A47/A11 Thickthorn Junction

Scheme Number: TR010037

9.16 Request for a Non-Material Change to the Application

REQUEST FOR A NON-MATERIAL CHANGE TO THE APPLICATION

Drawing Number: HE551492-GTY-LLO-000-DR-BL-30015	Rev: P02
--	----------

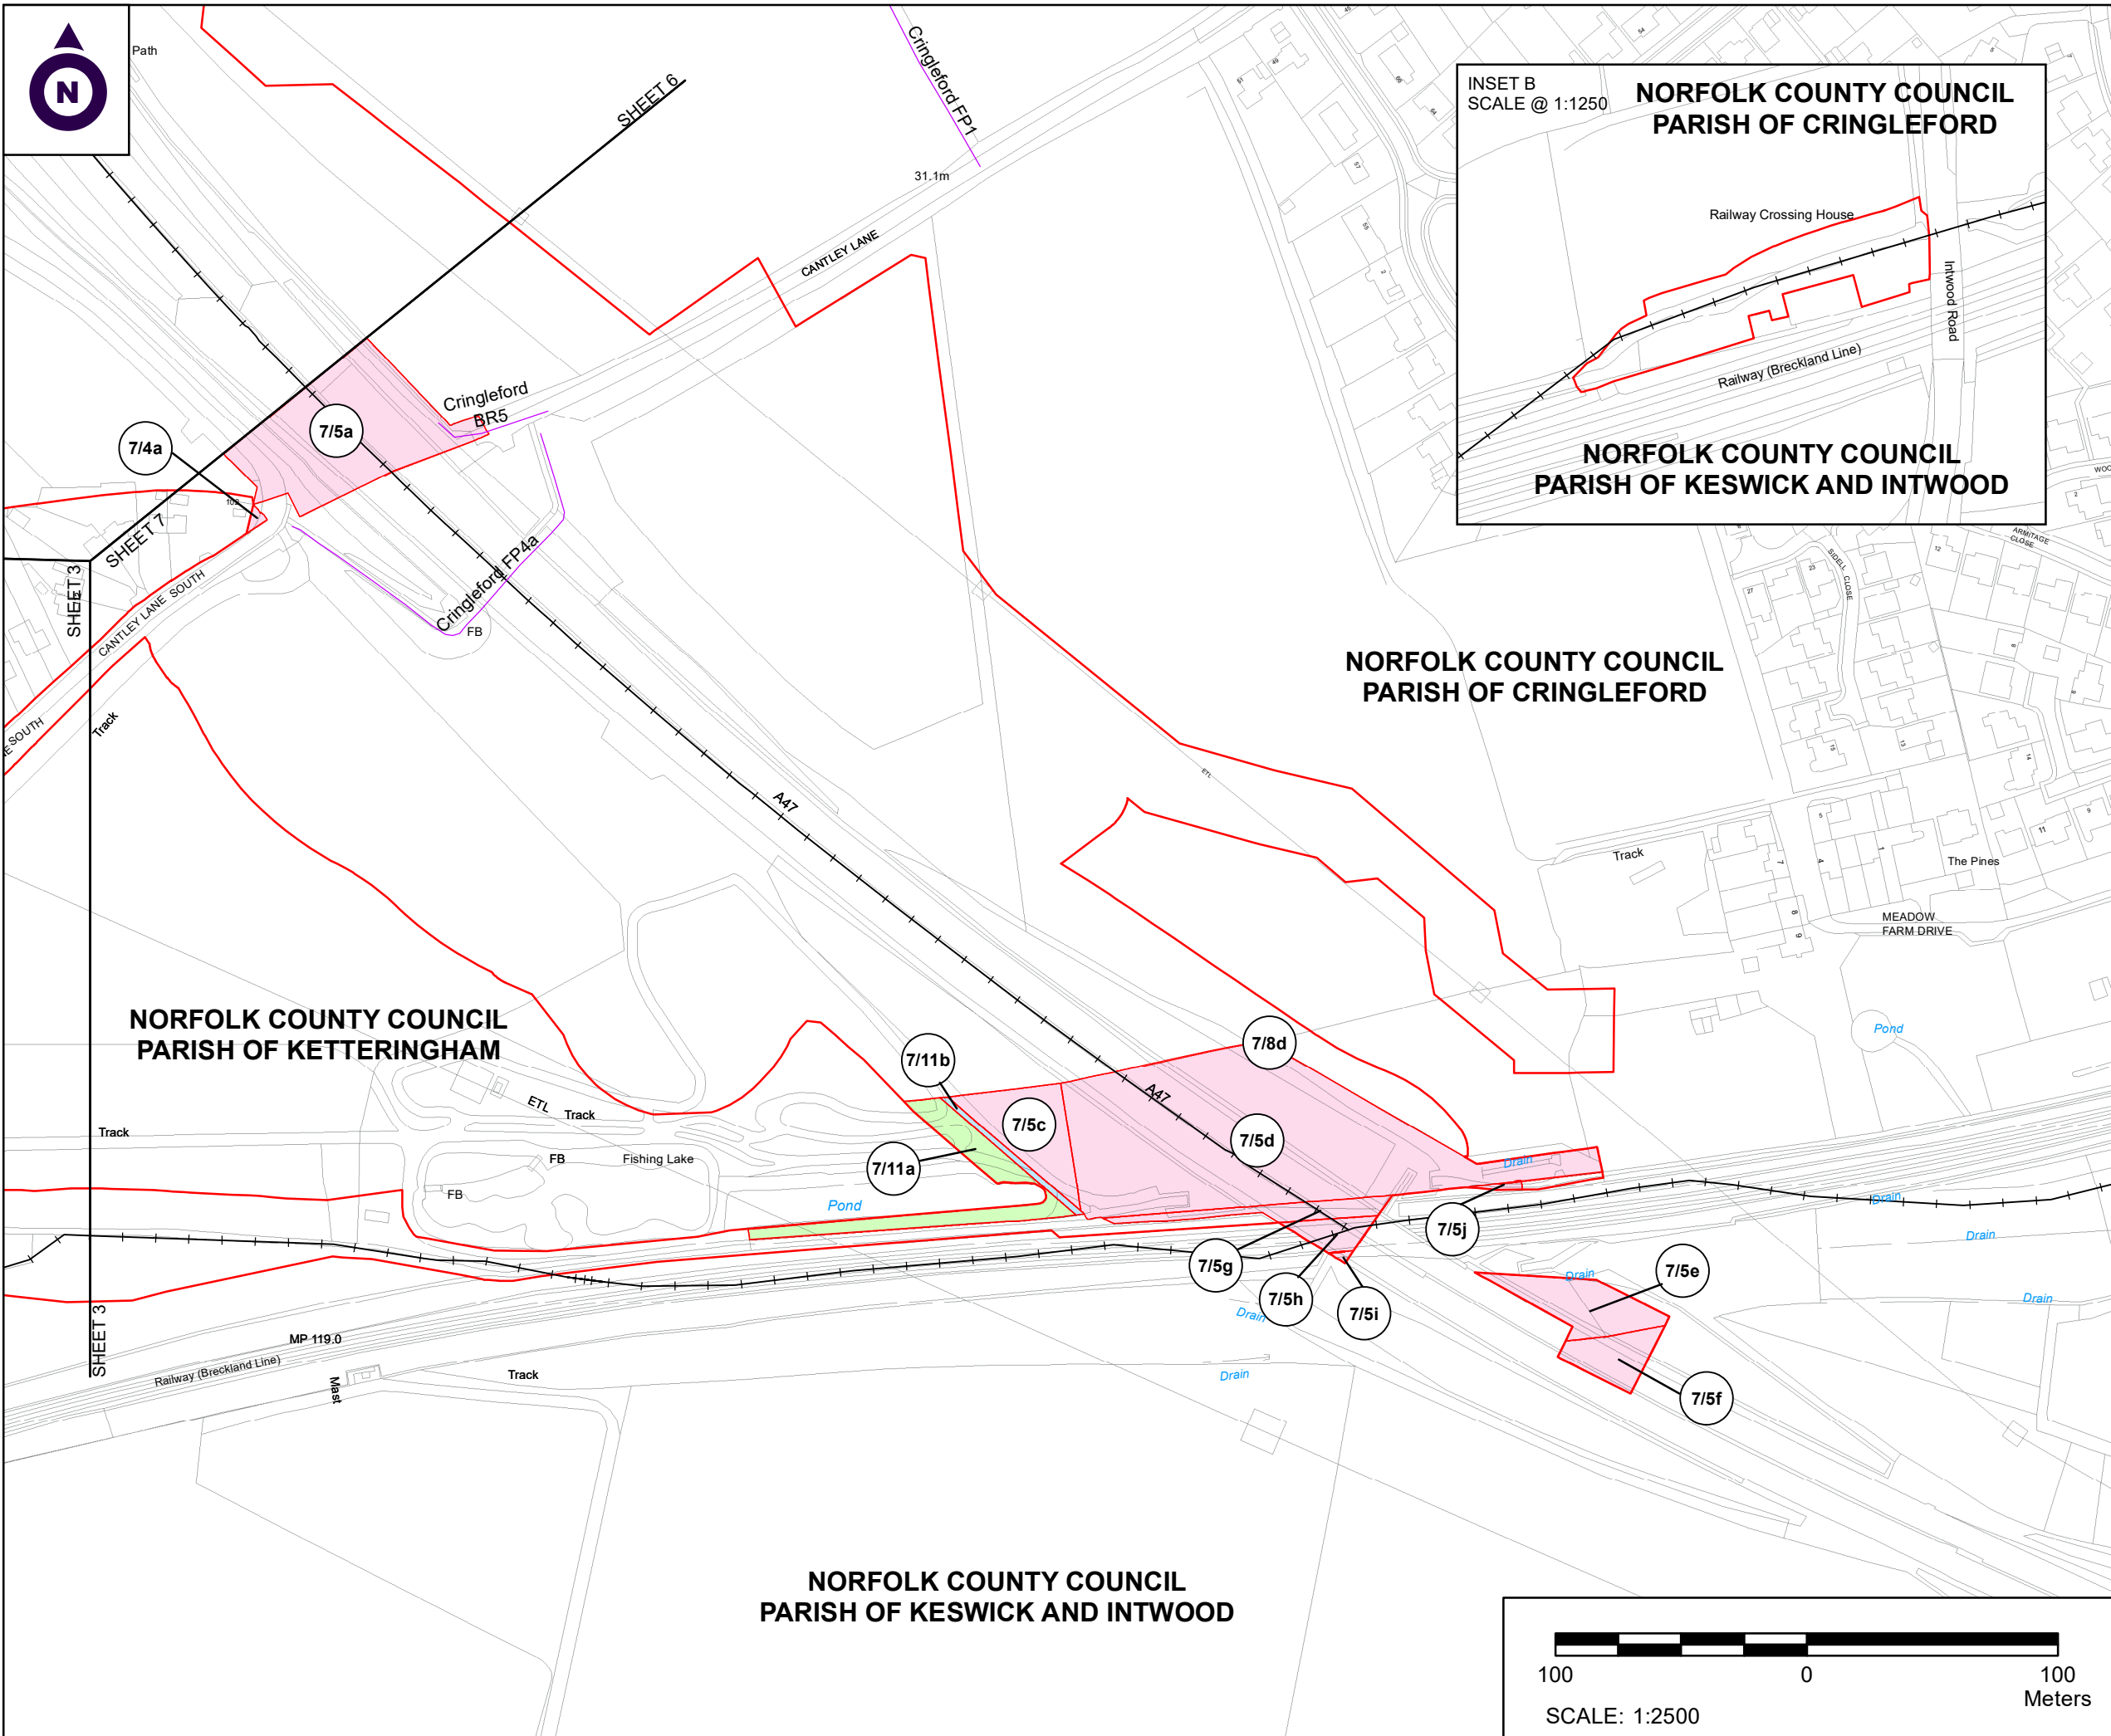
- 2.2.3 On that basis, the Applicant has no need to carry out any works to the property on Intwood Road or acquire any rights over the Property. Therefore, the Applicant wishes to remove this parcel of land from the Order Limits.

- 2.2.4 The Environmental Statement (ES) addendum addresses this change. No updates are required to any chapters within the ES.
- 2.2.5 The dDCO has been updated to remove Work No.45 from Schedule 1 and plot 7/12a from Schedule 7. This plot has also been removed from Annex A of the Statement of Reasons. Plot 7/12a should also have been removed from the Book of Reference (AS-003), however the Applicant has noticed that this plot had been mistakenly omitted from this document and therefore no change is necessary. Despite this omission, the Applicant can confirm that all those with an interest in Plot 7/12a were consulted in accordance with statutory requirements and will be notified that this plot has now been removed from the Order Limits.

- 3.1.1 A property on Intwood Road adjacent to the Cantley Stream was included in the Order Limits as initial flood modelling indicated a potential increased detriment in flood levels at the property, which would require local mitigation measures. This is shown as Plot 7/12a on the Land Plans (**AS-001**).
- 3.1.2 Additional survey information obtained around the property was used to update the flood model, which shows no increased detriment to flood levels at the property. The updated Flood Risk Assessment was submitted to the Examination at Deadline 3 (**REP3-008**). The Environment Agency agrees that no mitigation is required at the property.

removed and Inset A has been deleted
Special Category Land Plans	APP-013	7 of 7	The property on Intwood Road, east of the A47, south of Cringleford village has been removed and Inset A has been deleted
Classification of Roads Plans	APP-014	7 of 7	The property on Intwood Road, east of the A47, south of Cringleford village has been removed and Inset A has been deleted
Hedgerow Plans	APP-015	7 of 7	The property on Intwood Road, east of the A47, south of Cringleford village has been removed and Inset A has been deleted
Environmental Masterplan	APP-123	5 of 5	The property on Intwood Road, east of the A47, south of Cringleford village has been removed and Inset A has been deleted
Draft Development Consent Order	REP3-002	N/A	Work No. 45 has been removed from Schedule 1 and plot 7/12a has been removed from Schedule 7
Statement of Reasons	APP-020	N/A	Plot number 7/12a has been removed from Annex A
